Crown Castle
200 Spectrum Center Drive
Suite 1700
Irvine, CA 92618

RE: WCF21-036, 8215 SE 78th St, Mercer Island

I am providing the additional materials requested in response to your compliance review letter dated January 4, 2022, for the following referenced Application. Below I will note each item listed on the review as missing or incomplete and provide a response to satisfy each item of record.

SHEET NUMBER: **A1.1** PAGE: **2 OF 7**

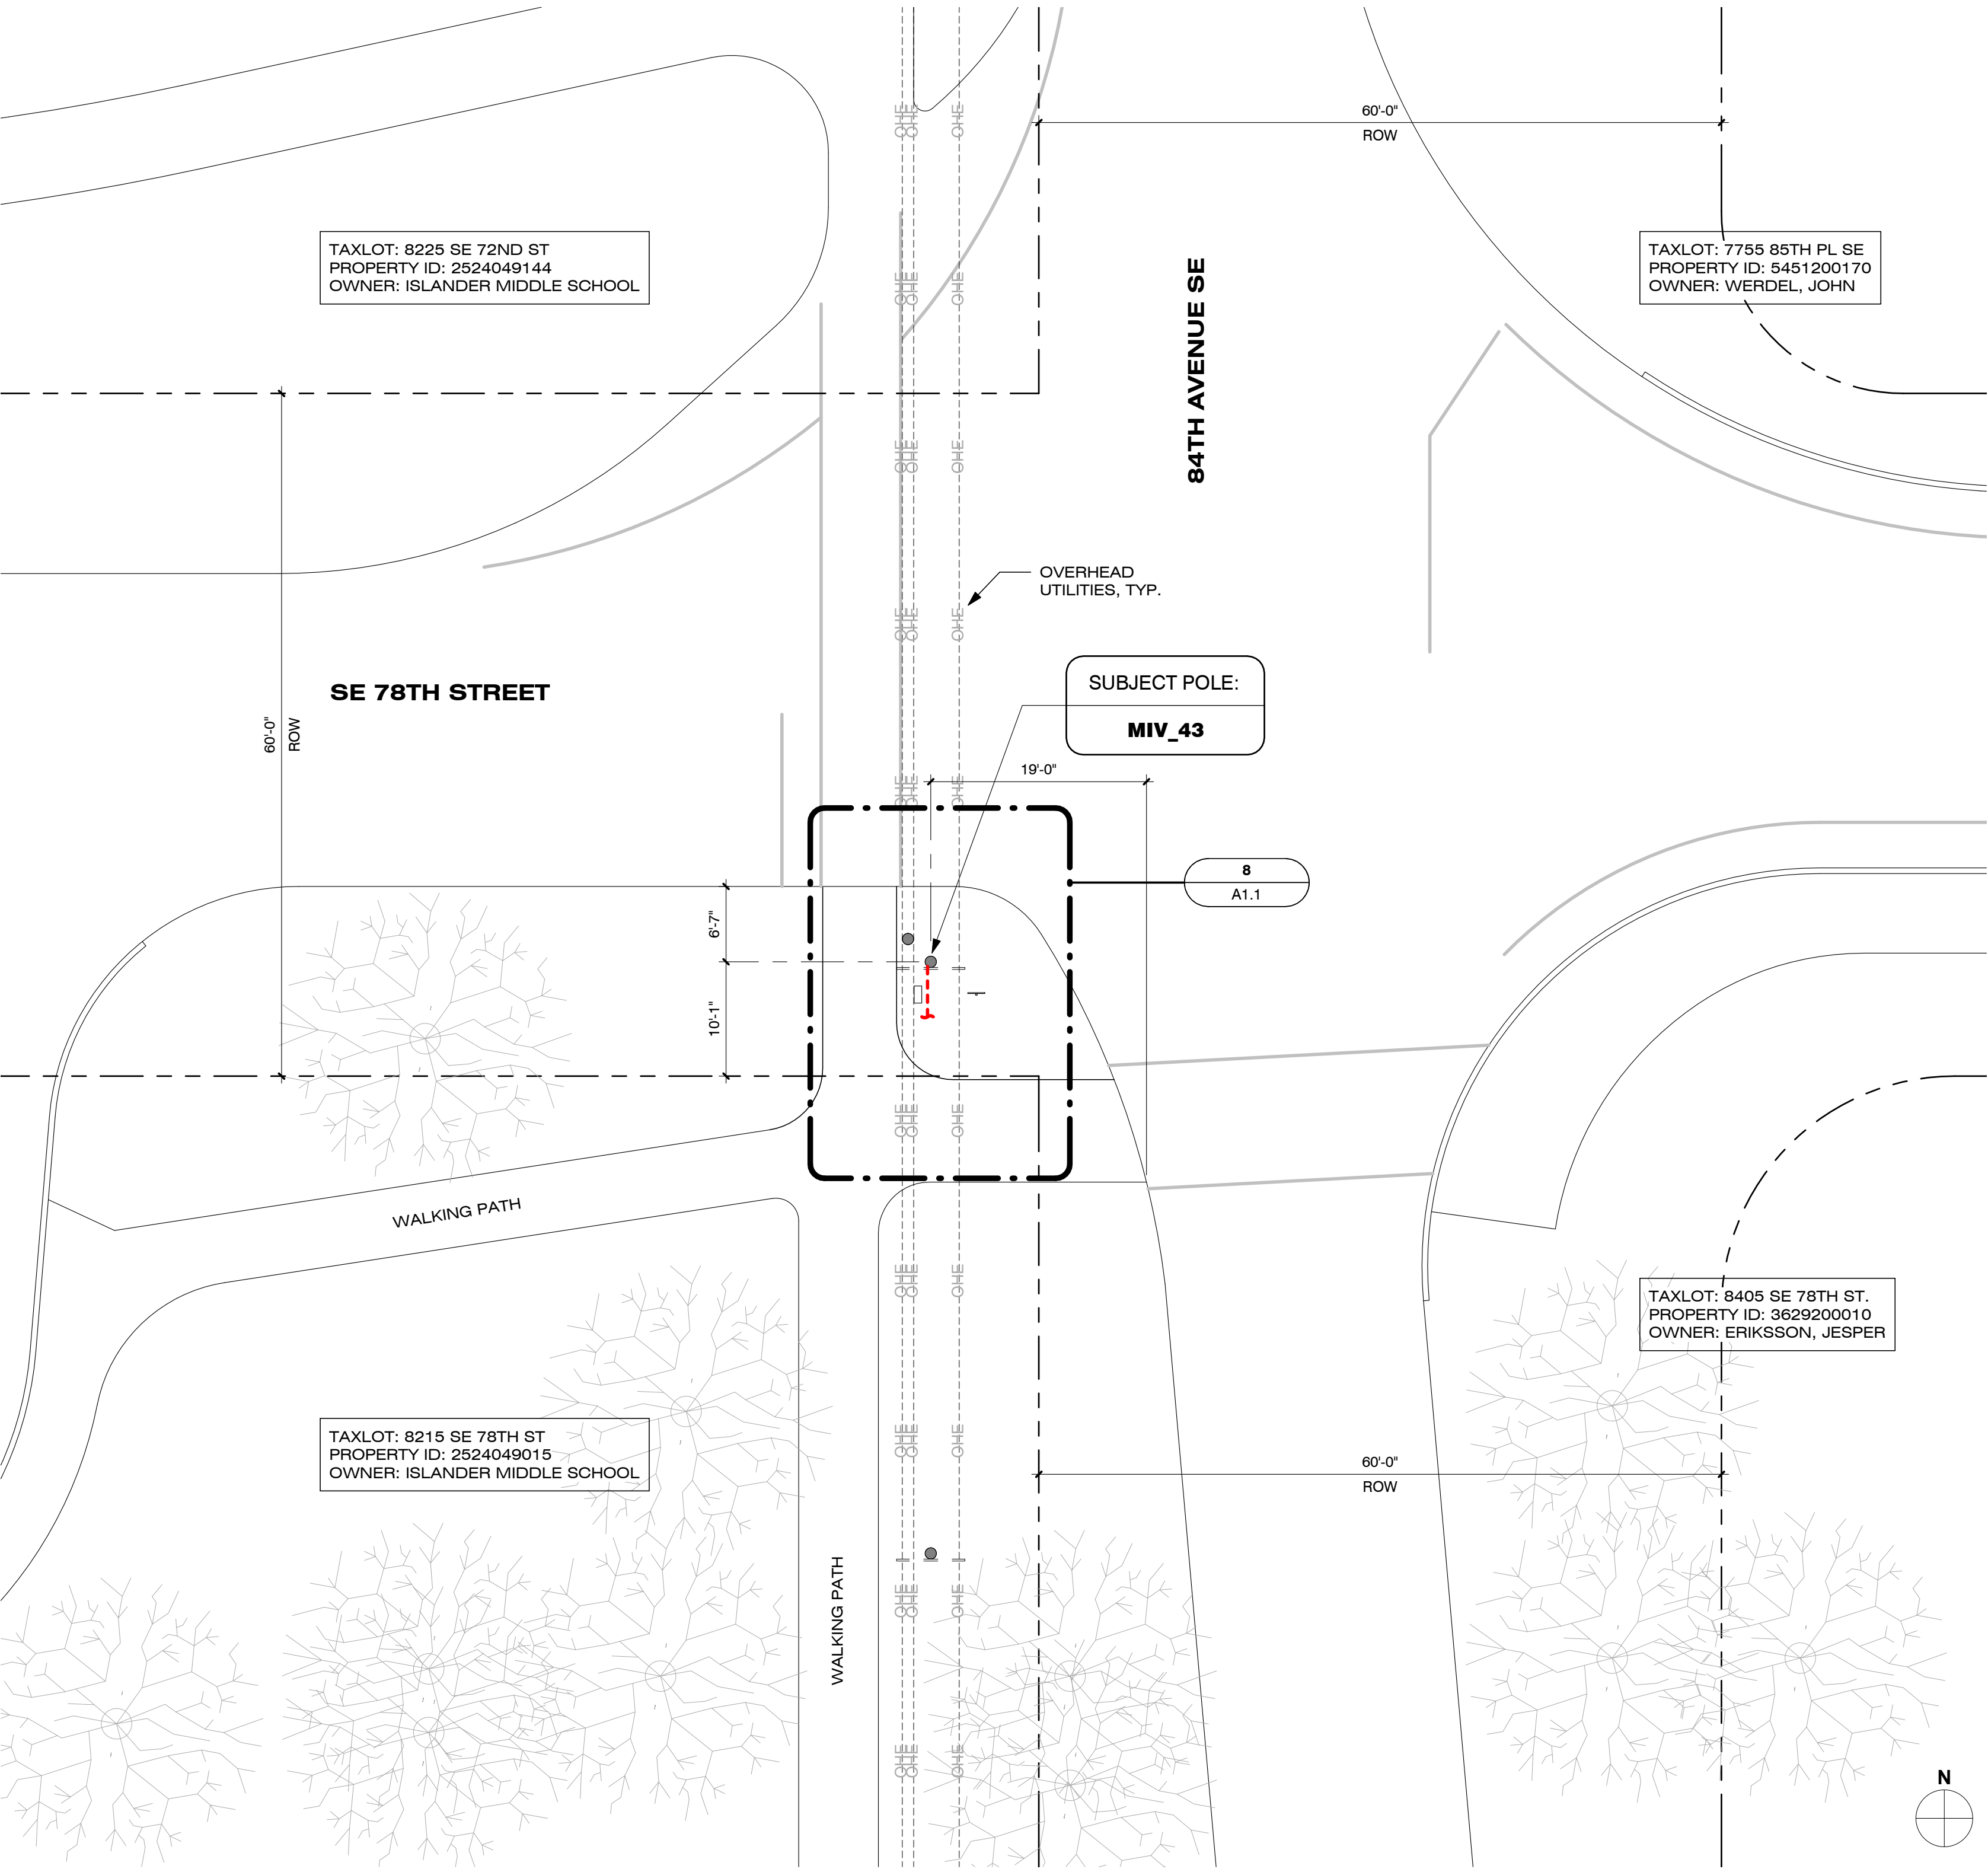
- 2. MICC 19.06.075(A)(1) states that ground-mounted equipment in the rights-of-way is prohibited unless such facilities are placed underground or the applicant can demonstrate that pole-mounted or underground equipment is infeasible. If ground-mounted equipment is necessary, then the applicant shall submit a concealment plan pursuant to MICC 19.06.075(G). In the new application for a modification to an existing small cell facility, please revise the location of the equipment cabinet so it is not ground mounted or provide a concealment plan for the cabinet consistent with MICC 19.06.075(G).**

Crown Response: Please see revised drawings, the proposed meter pedestal is painted to match the existing telco pedestal adjacent to the pole. Crown Castle is proposing to install a standard electrical meter pedestal that is common industry equipment for metering. The proposed Myers MEUG16 is designed to be placed on finished grade, not underground. Undergrounding electrical equipment would pose a public safety concern. Any equipment placed underground would require a vault/pump so that accumulation of water is removed rapidly. Pump failure would have additional liability. In addition to the limitations for placing this meter underground, are the limitations to place a meter on the pole. In addition to design restrictions, PSE prohibits the placement of carrier's meters on poles. Upon further assessment of the area, there are existing

meter pedestals currently being used for other purposes. This fact establishes a precedence in which Crown Castle is asking for relief to MICC 19.06.075(A)(1).
